Planning Application No: 3/2024/0089

Proposal: Proposed demolition of part of existing pigsty and construction of single storey extension to side and rear.

Location: 23 Smithy Row Hurst Green BB7 9QA

The submitted documents and plans have been reviewed and the following comments are made.

PROPOSED SITE PLAN
23 SMITHY ROW
HURST GREEN

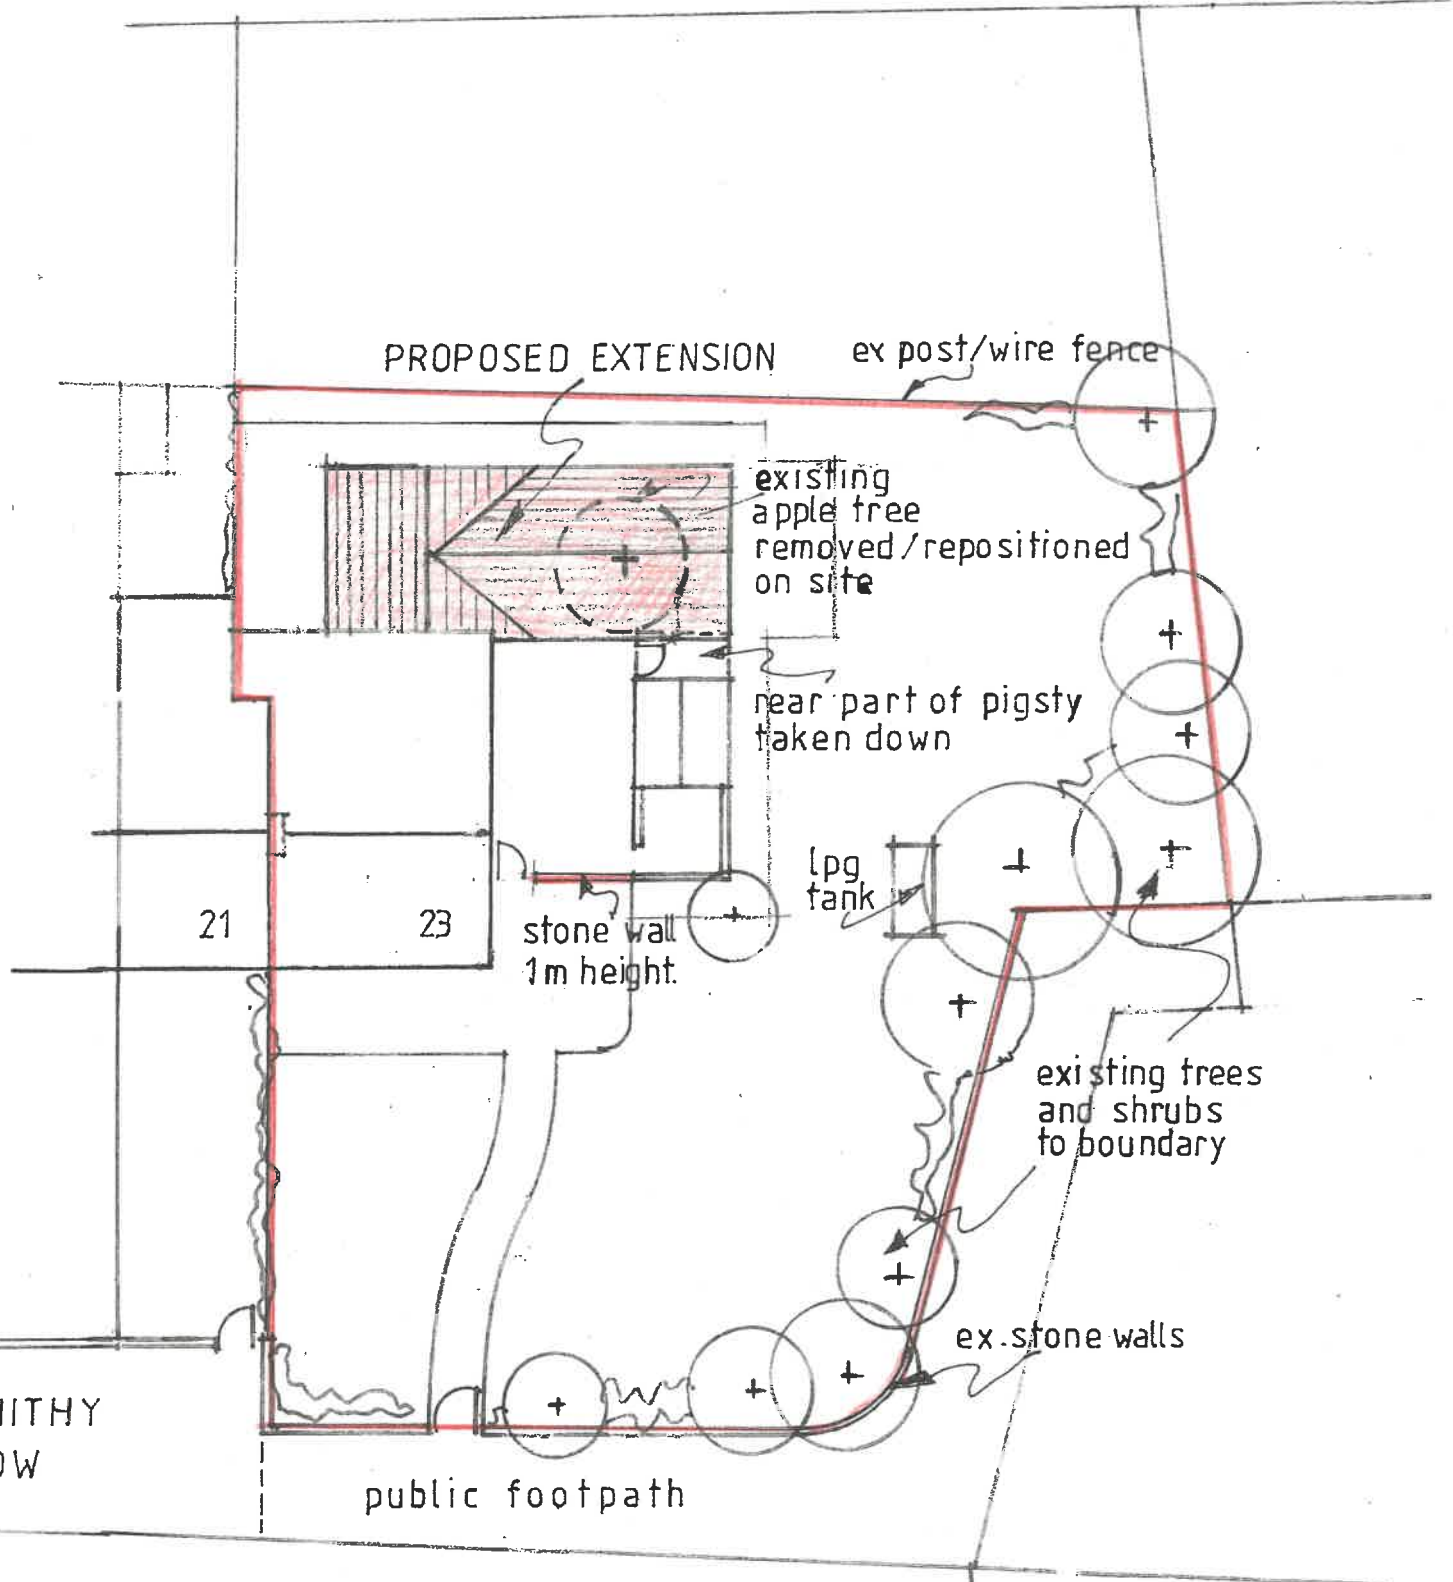
There is no objection to the proposal, however, public right of way FP0303066 should not be obstructed during construction works.
